TECHNICAL NOTE

File Ref: MA/CS/P21-2319/01TN

Subject: EL Dowley – Deadline 2 Submission

- 1.2 The [REDACTED] lies towards the West of the existing Sizewell Power Station and as part of the access arrangements to serve the proposed scheme, a new five-arm roundabout is proposed on the B1172 Abbey Road to the East of Leiston Abbey. The schematic layouts of the junction are presented at Appendix A of this note for convenience.

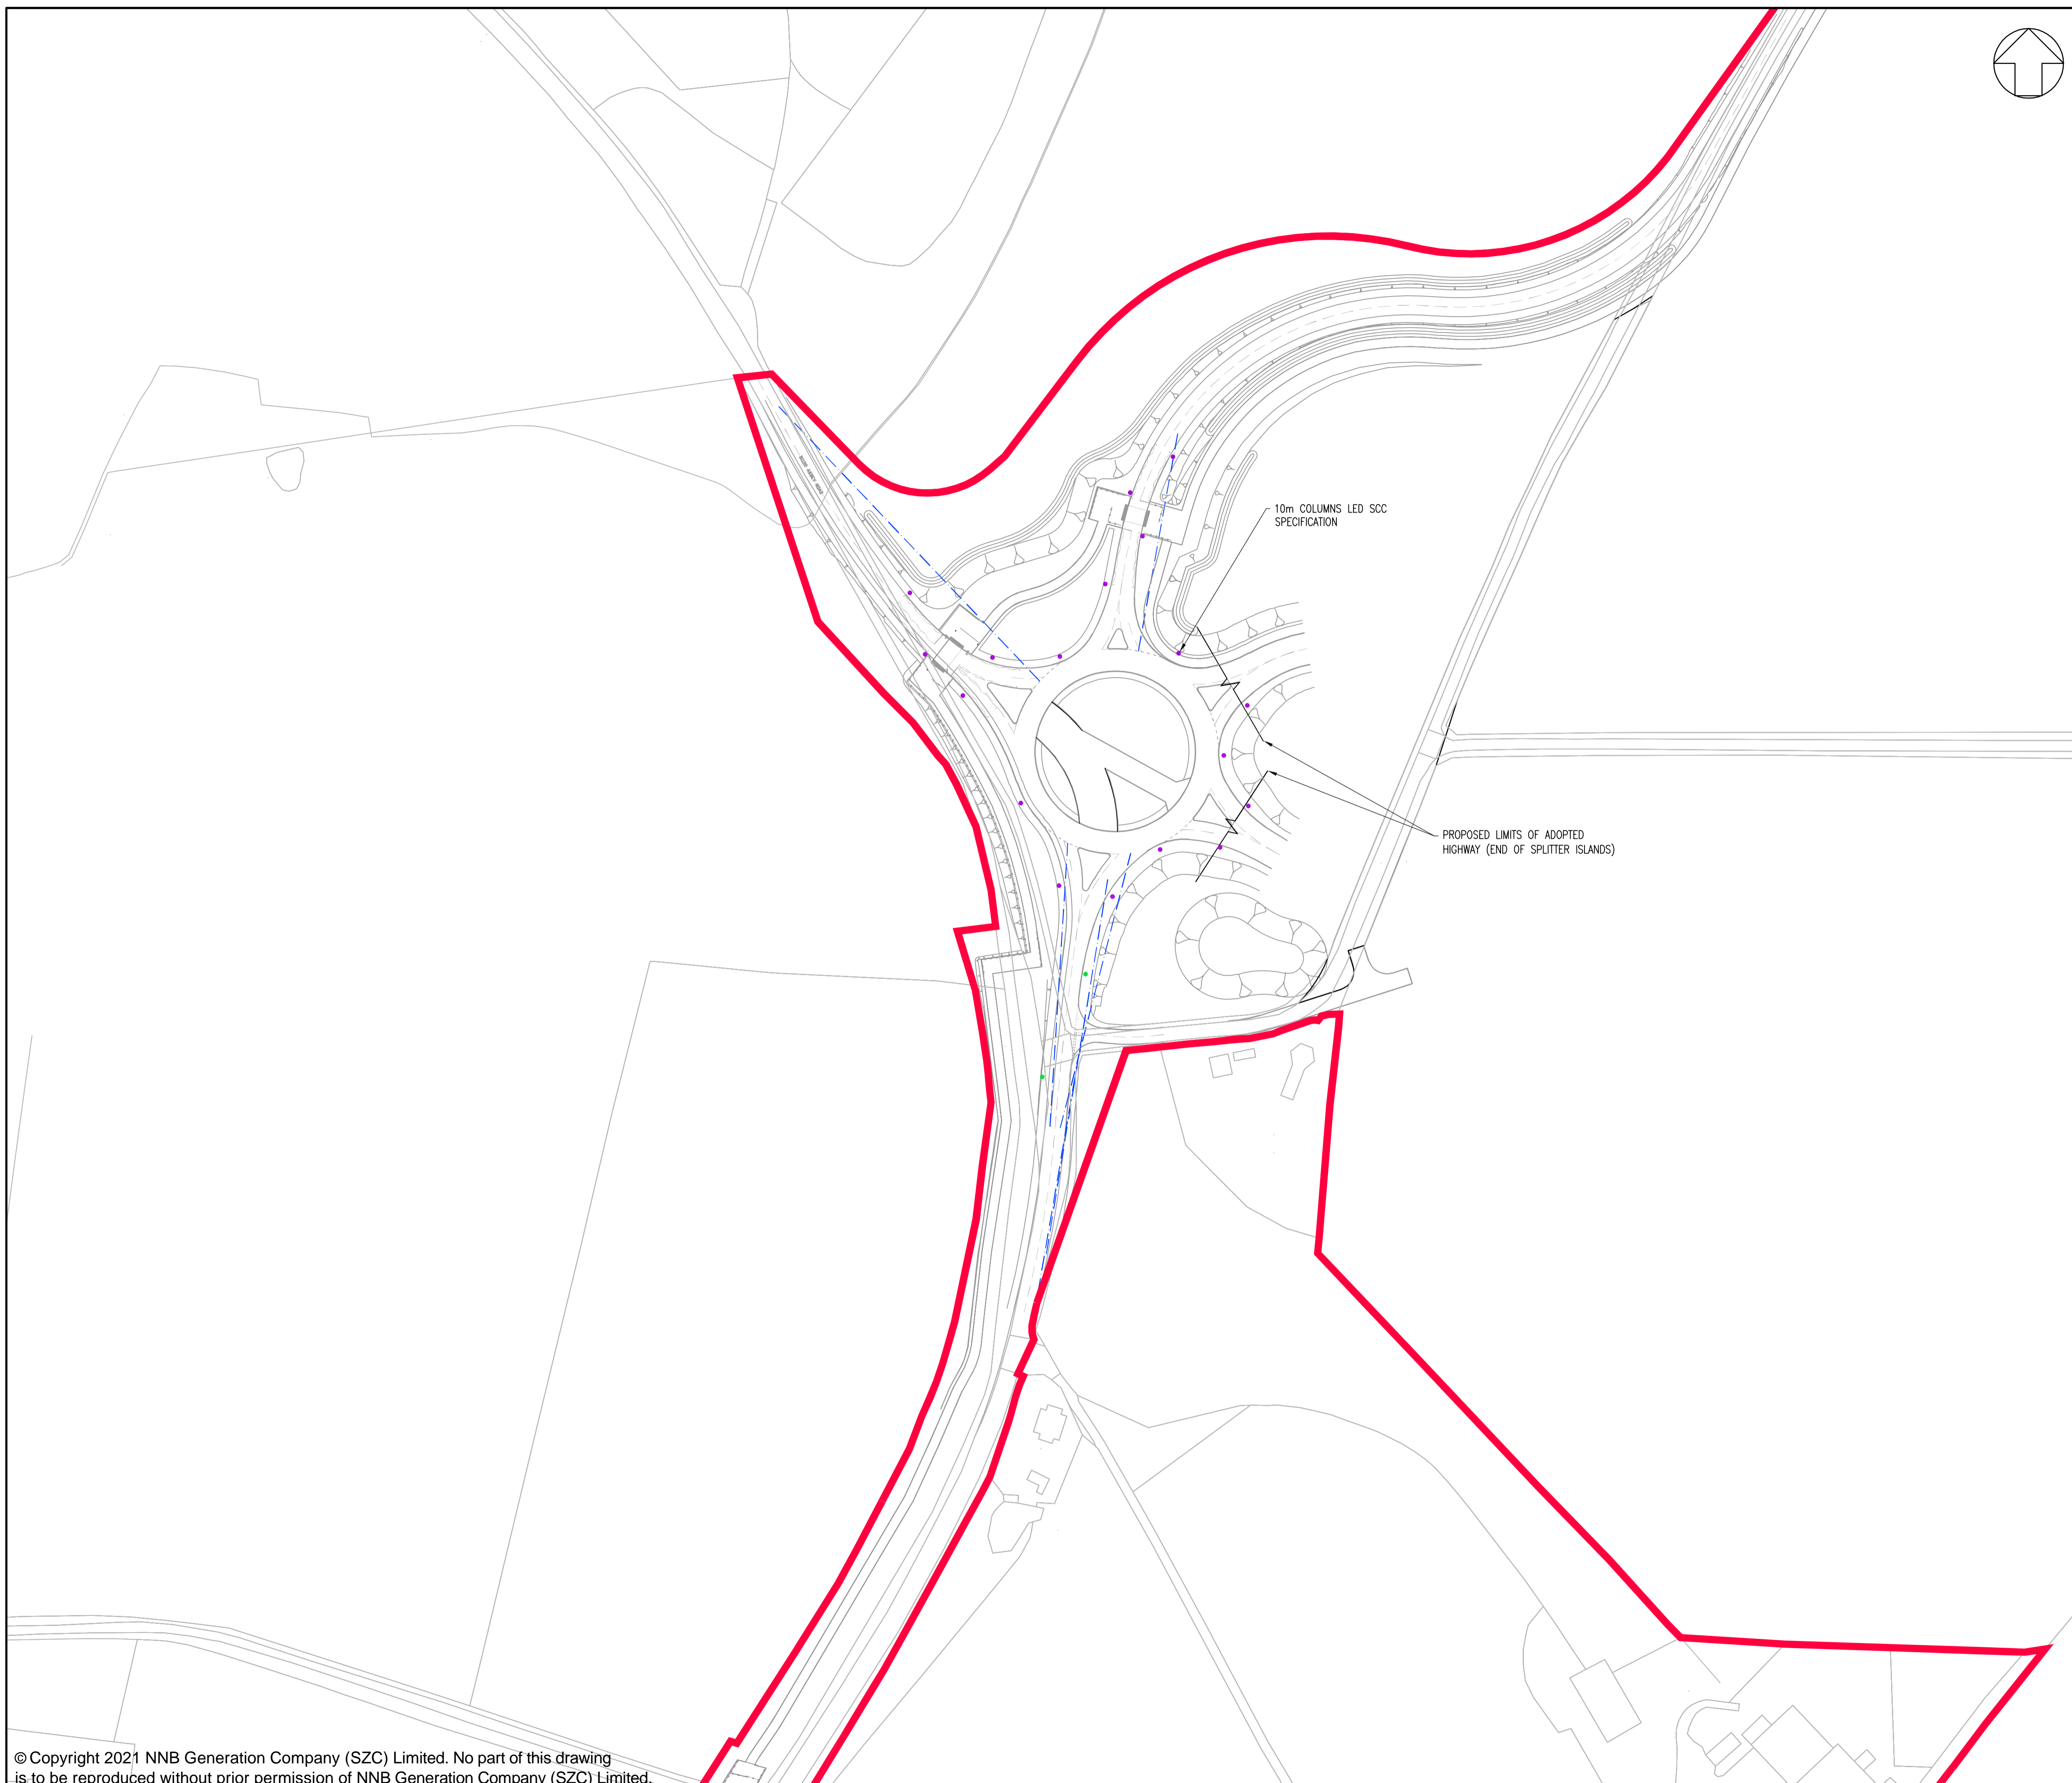
- 2.3 The large ICD of the proposed roundabout will mean that illumination will be a significant issue at this location with the junction fully lit.
- 2.4 Create have reviewed the lighting proposals and consider this will result in widespread light pollution at this rural location.
- 2.5 The case for full street lighting at this location would need to be fully justified with mitigation put in place if this is deemed necessary, no light pollution mitigation is currently proposed by

the Applicant and at present, the current scheme design put forward is not considered to be acceptable to our Clients.
